APPENDIX D RECOMMENDED CHANGES TO CONDITIONS

- A13. Prior to the lodgement of the first Future Development Application, the Applicant shall revise the Sydney Metro Martin Place Station Precinct Consolidated Design Guidelines (dated September 2017), to the satisfaction of the Secretary, as follows:

Diagram illustrating urban design principles for tower level

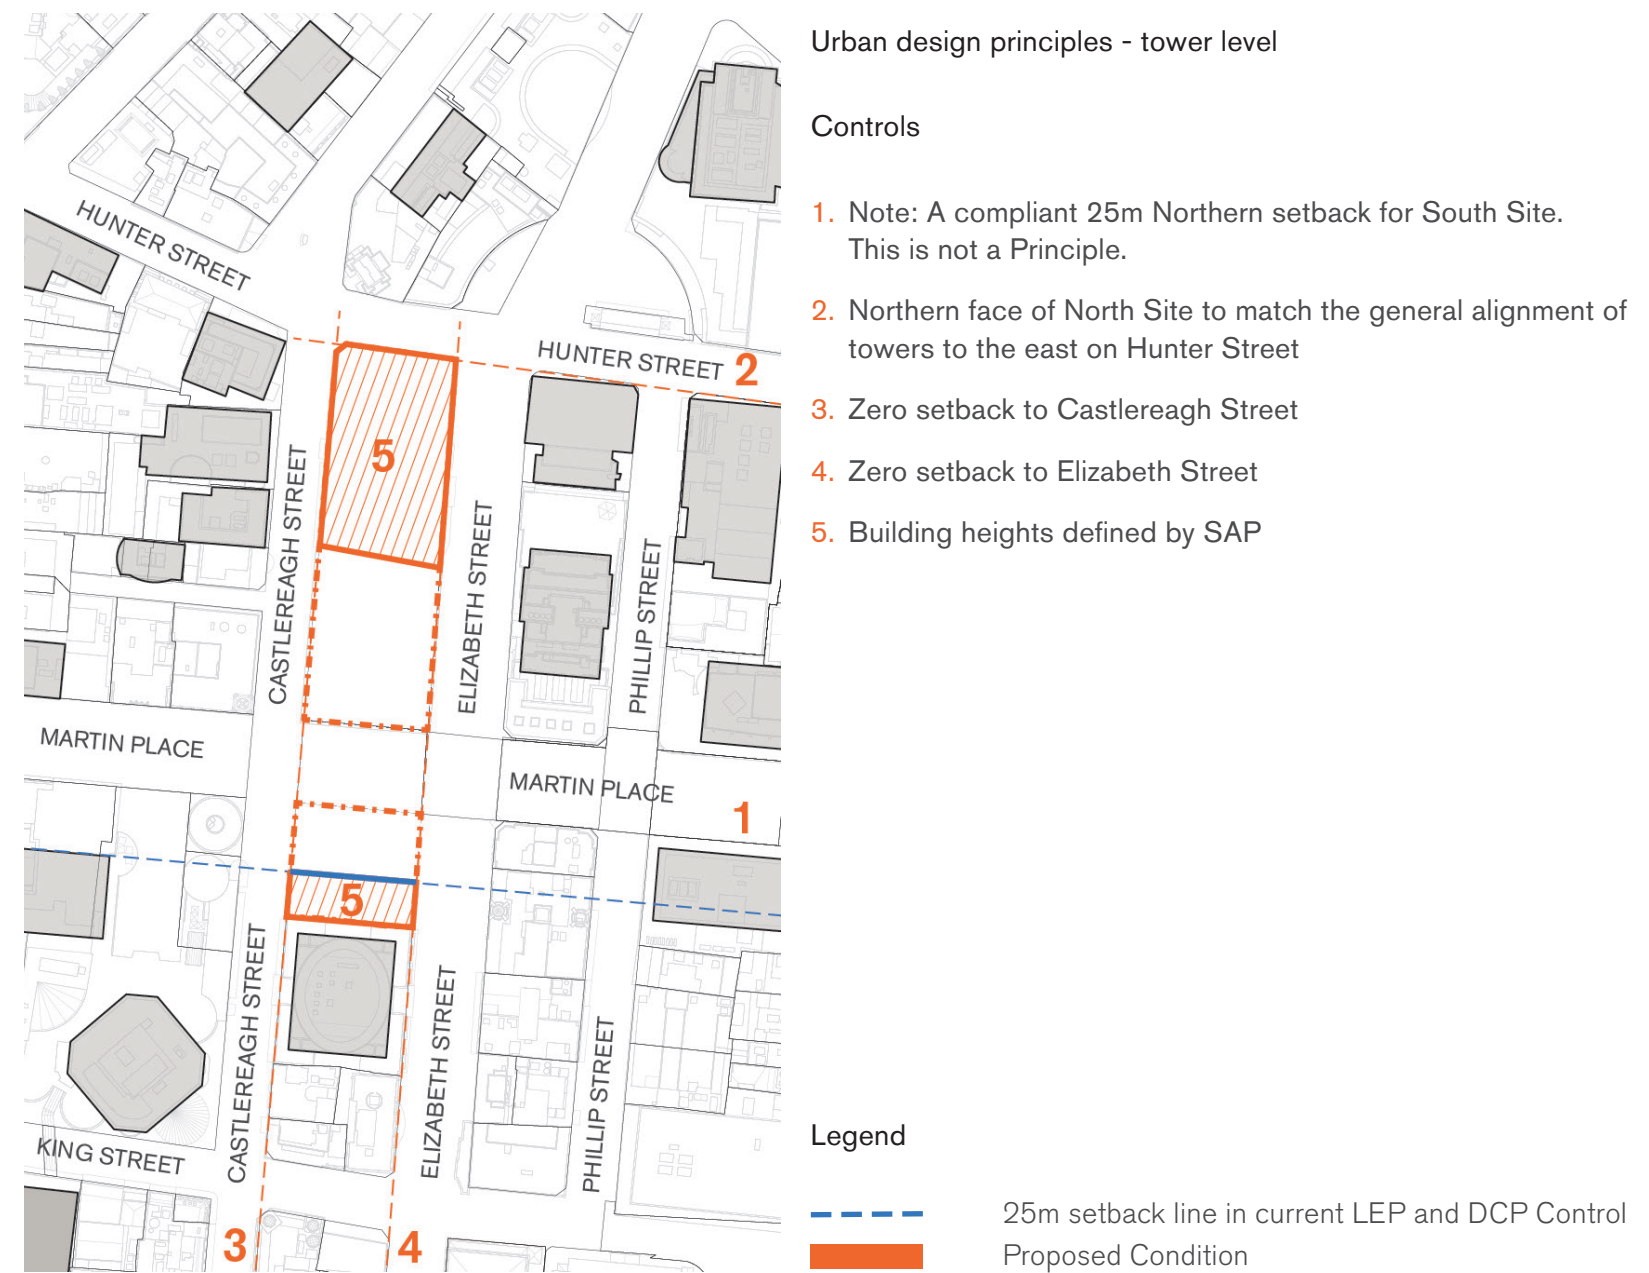
- q. In 2.4 (Graphic Representation of Development Principles): Amend diagram titled 'urban design principles – tower level' to delete points 3 and 4 (zero setback to Castlereagh and Elizabeth Streets) and renumber accordingly.
